| Application number: 2026/91456   |                                                   |
| What is the application for?:    | Formation of patio and steps                      |
| Address of the site or building: | 38, Grange Avenue, Marsden, Huddersfield, HD7 6AQ |

## User comments

Drawing number
02 A.

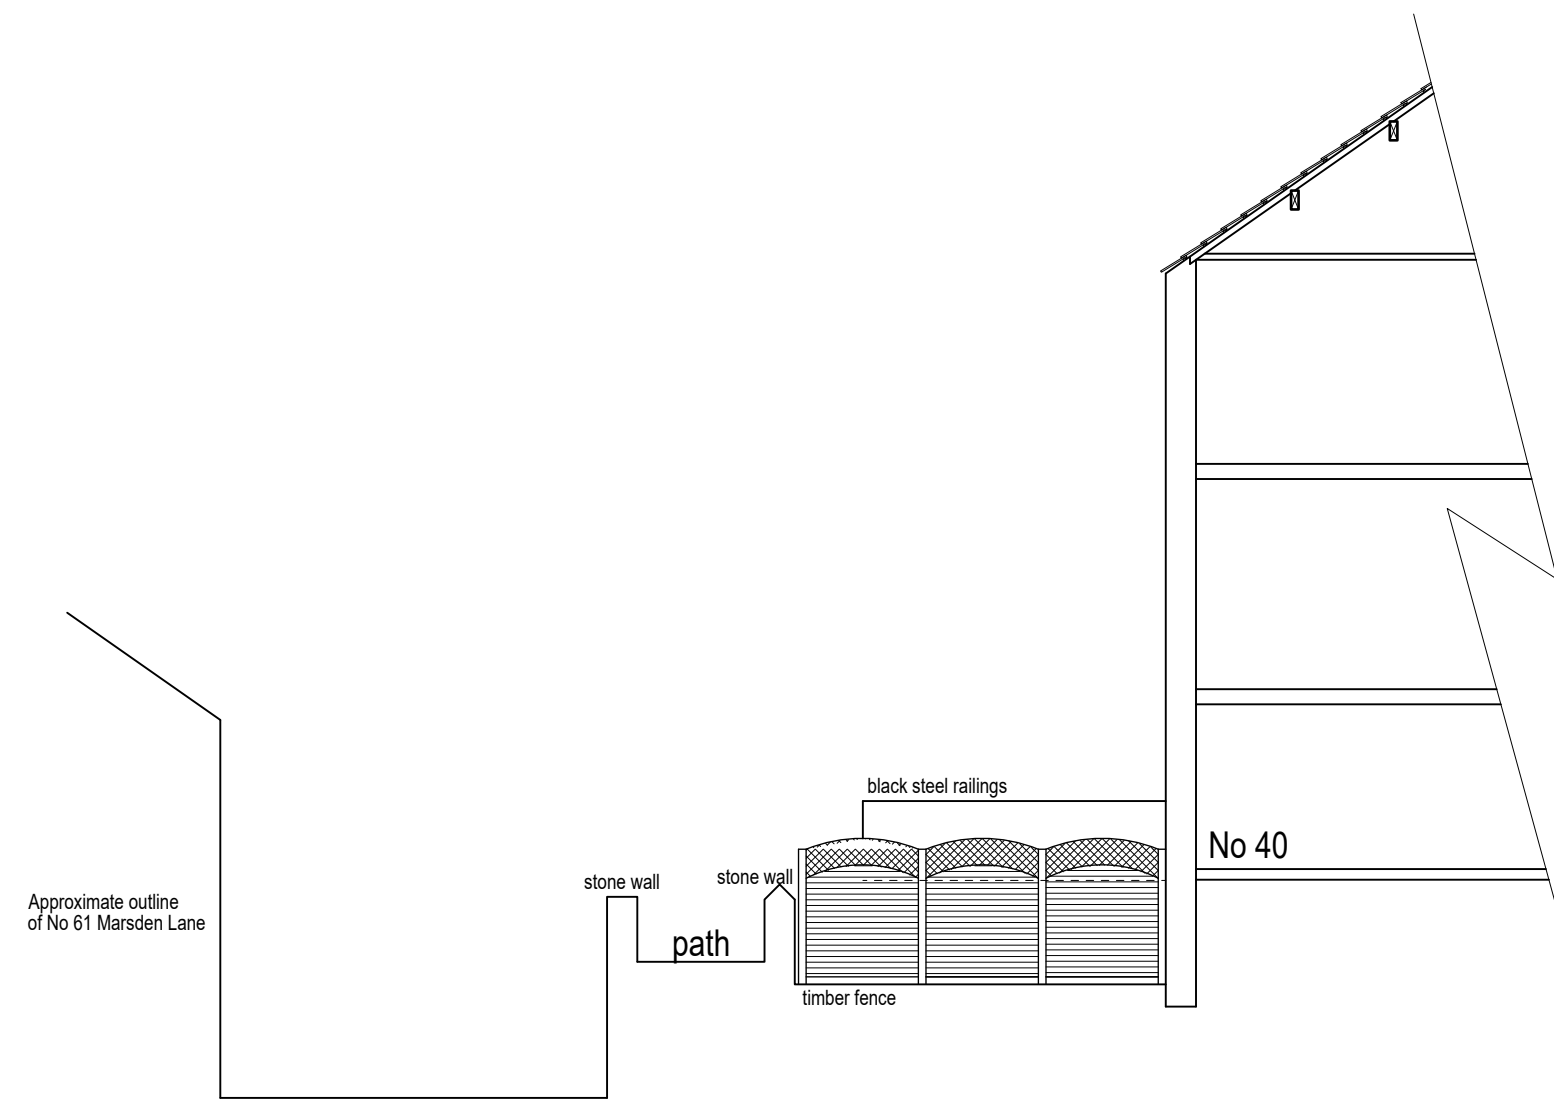
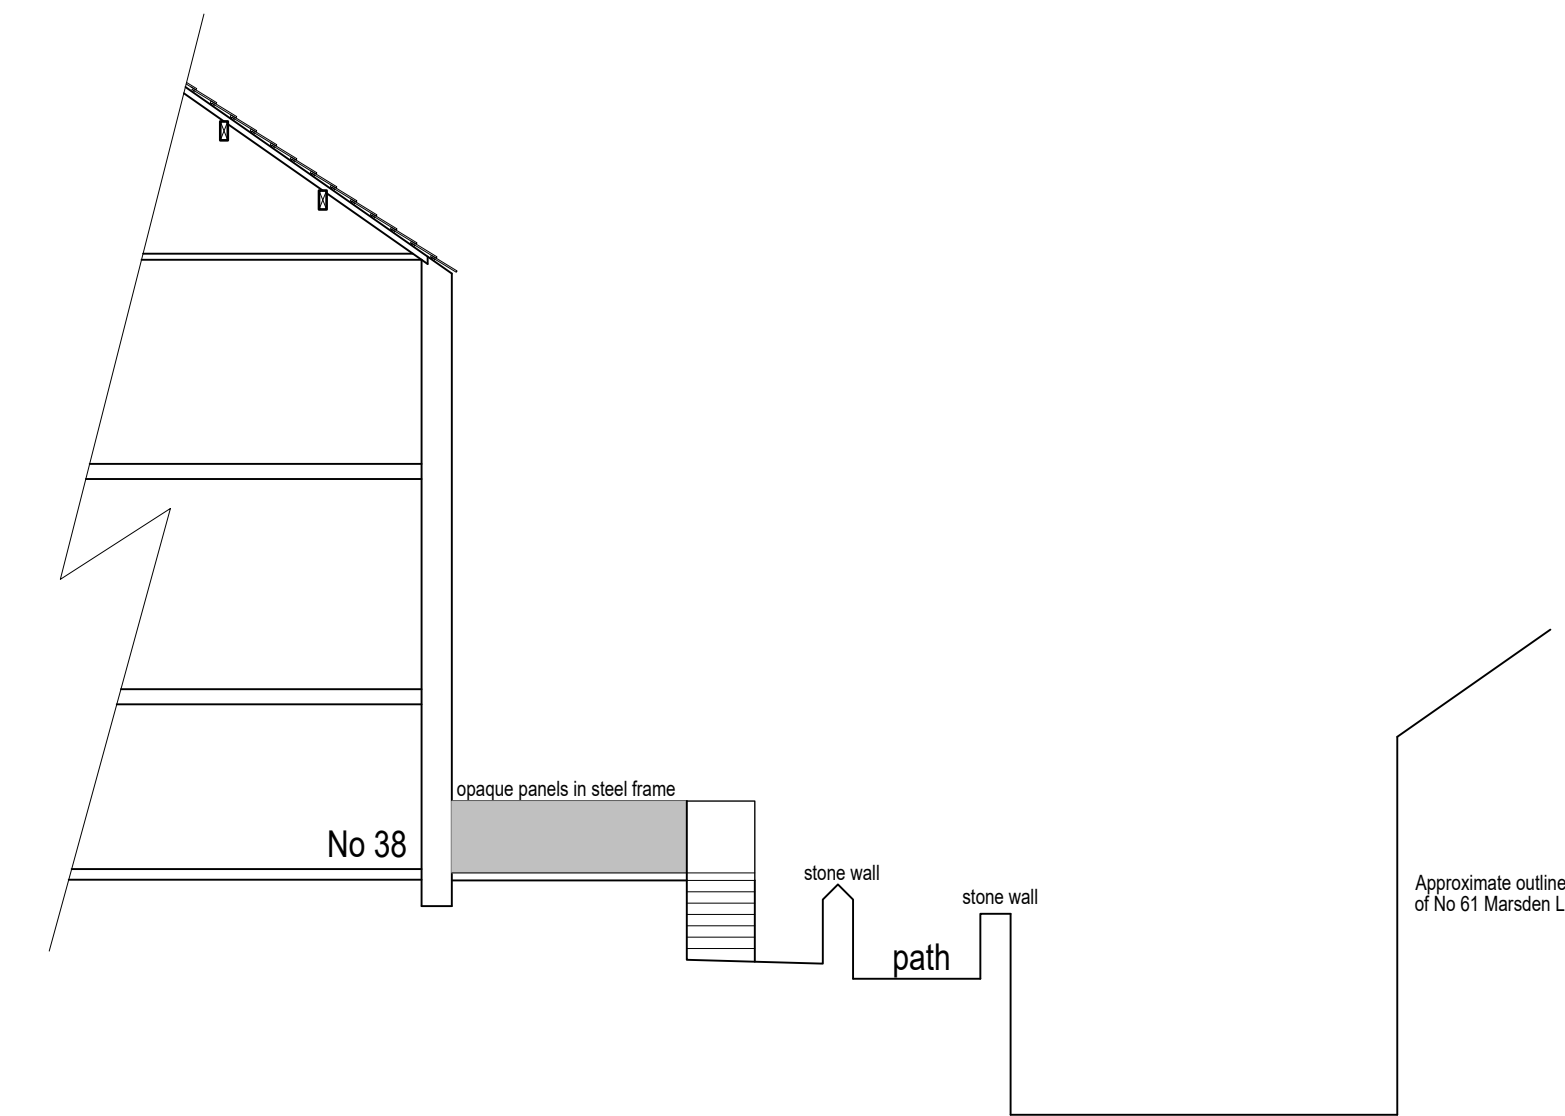
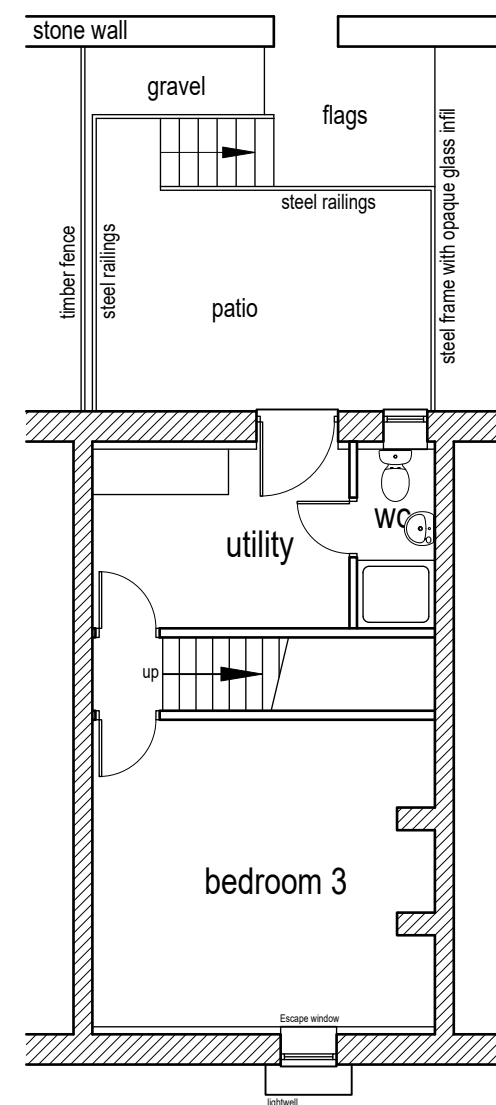
| <p>This has already been built. It i have no privacy and are overlooked. There is white stuff leaking out the side next to me. This build is over the gas pipe and waste drain that run full length of the street. If there is any problems in future they will have to dig out. This is over 6feet tall with blocked out railings. I do not feel this is a patio but a platform that takes away adjoining houses privacy.</p> <p>.</p> |     |
